1ST FLOOR FRAMING PLAN
WALLS AND CEILING
N.T.S.

ADAMS HOMES		REV #	REF PROJ #	DATE
SCOPE:	MISSING ANCHOR BOLTS			
LOC:	116 KIPLING CREEK

PROJECT NO.
25-75-667

FOUNDATION PLAN
MONO SLAB OPTION
1/4" = 1'-0"

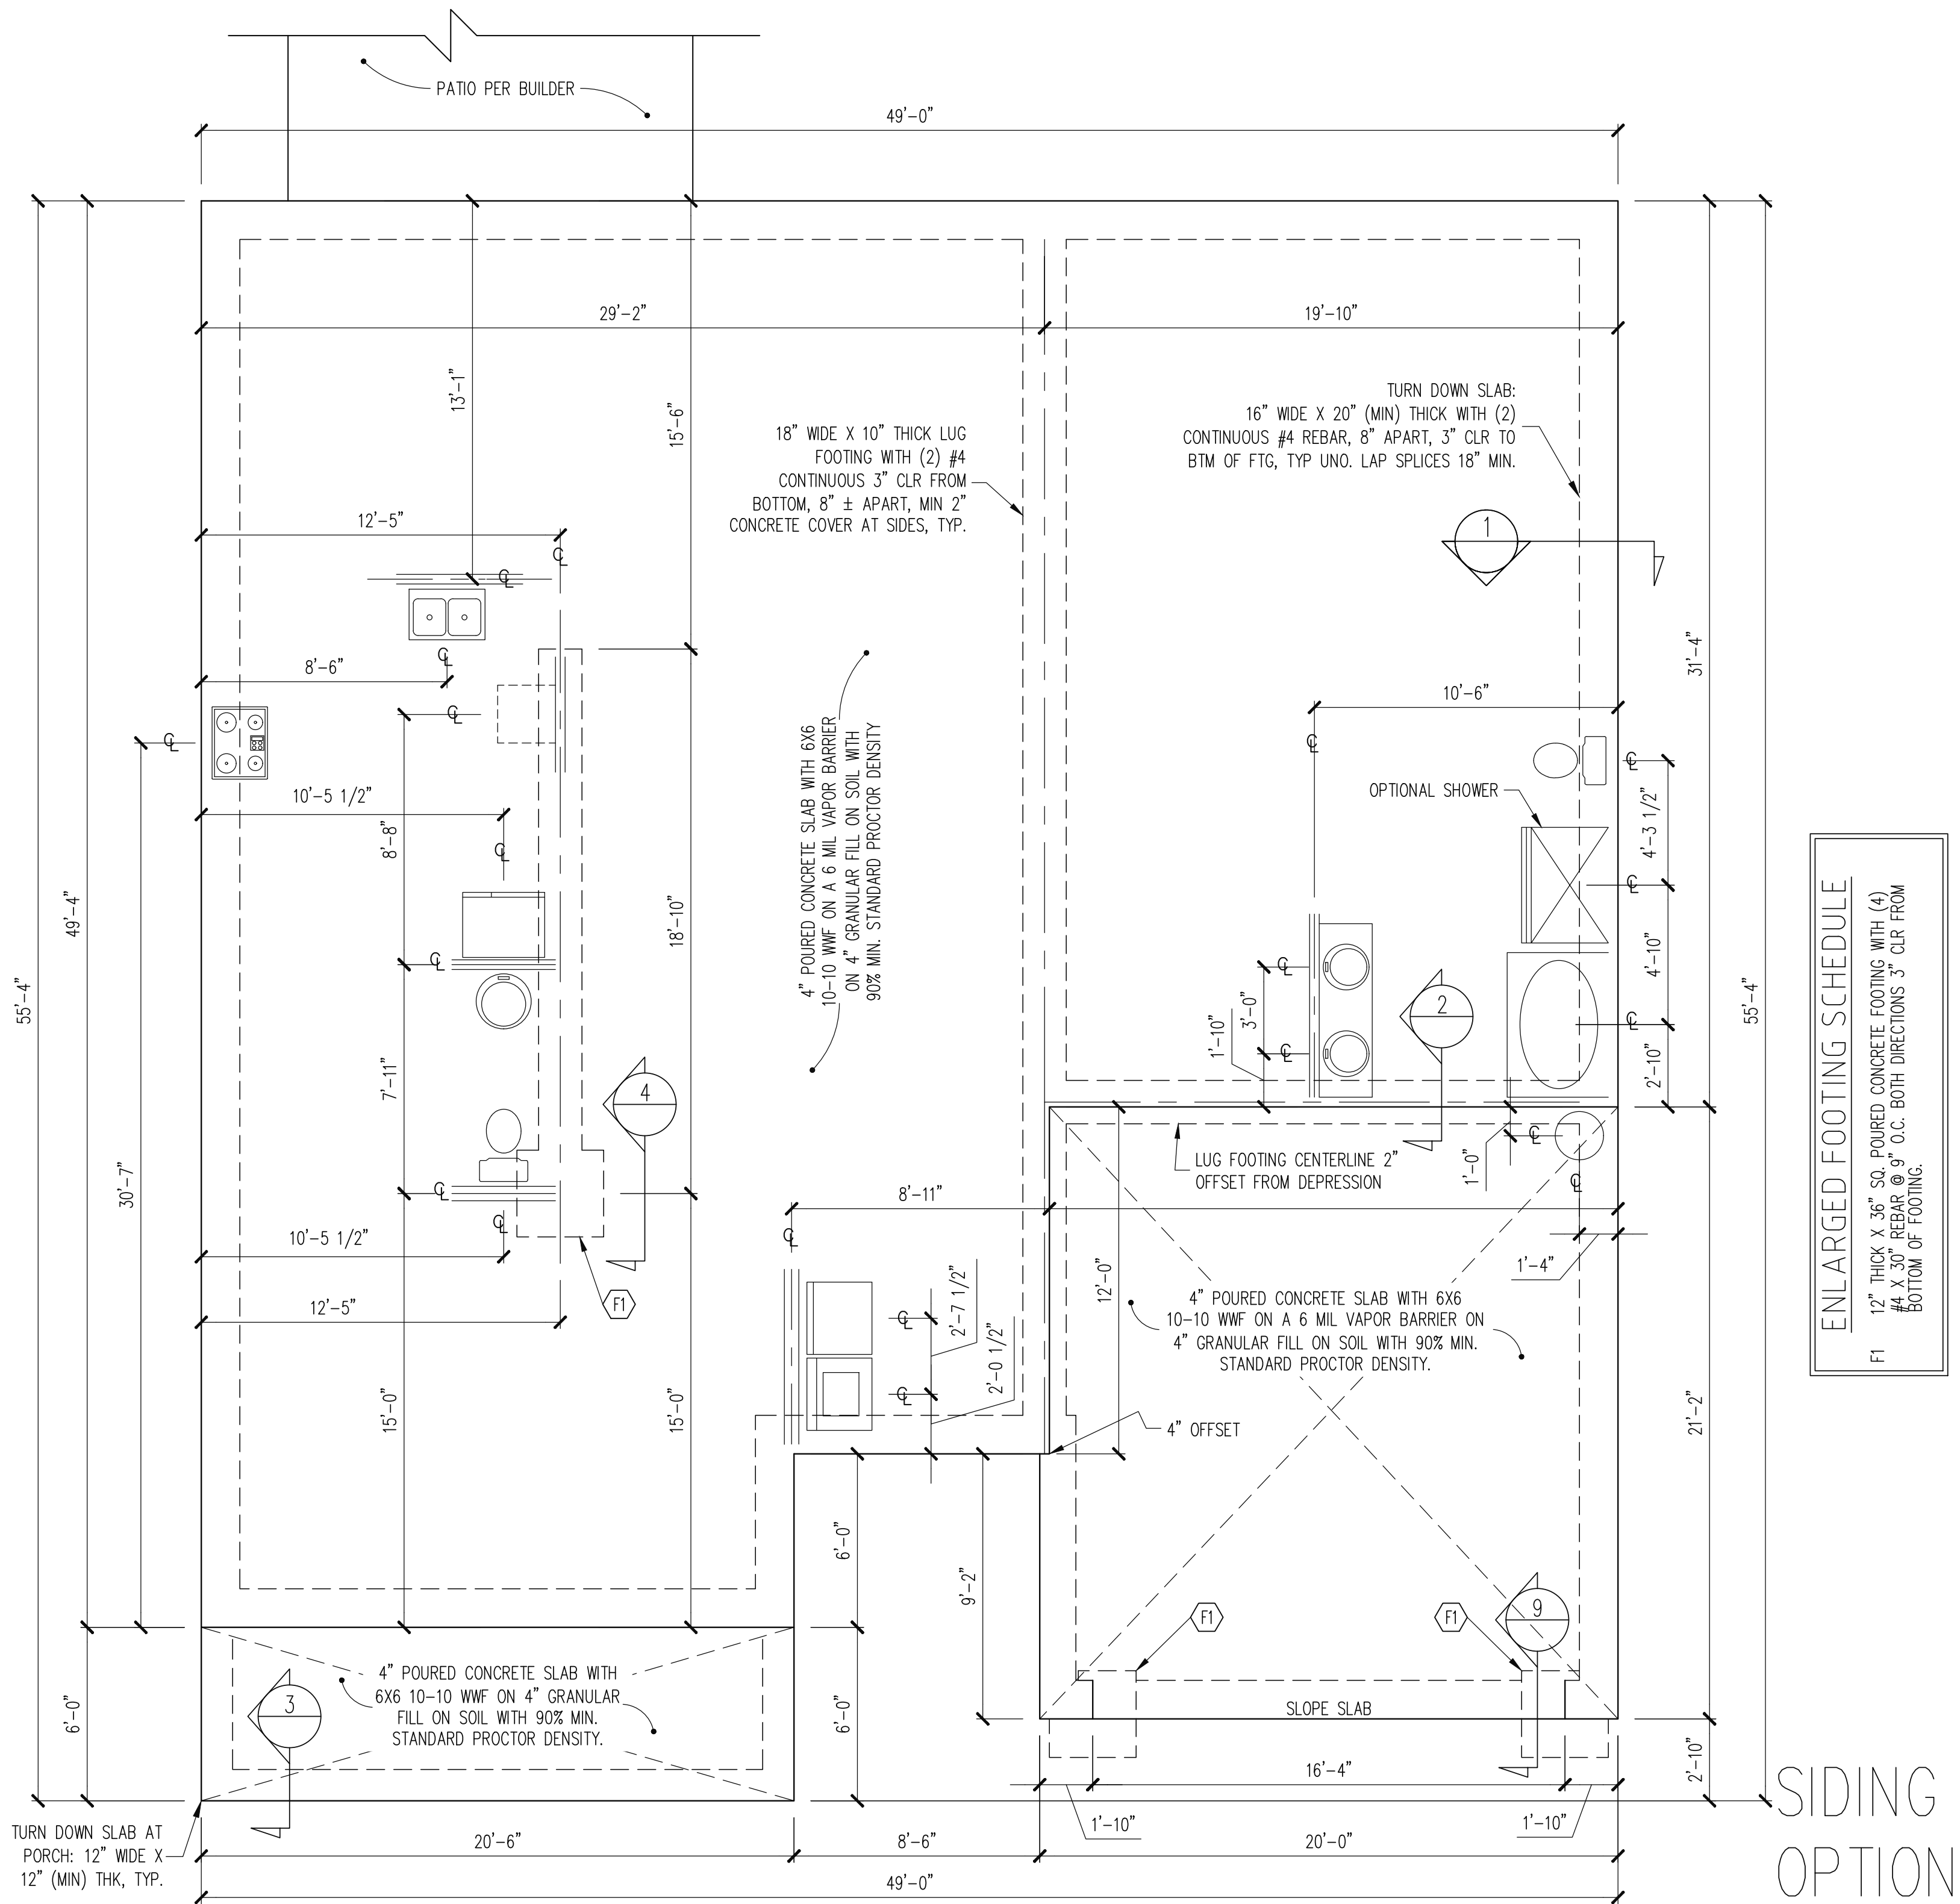
** TAPCON LDT 125 SCREWS (OR EQUIVALENT) REQ'D @ 6' O.C., 12" MAX FROM WALL CORNERS AND SOLE PLATE SPLICES IN LIEU OF WET SET ANCHOR BOLTS. MIN (2) SCREWS PER SOLE PLATE SEGMENT TYP @ CLOUDED WALLS. **
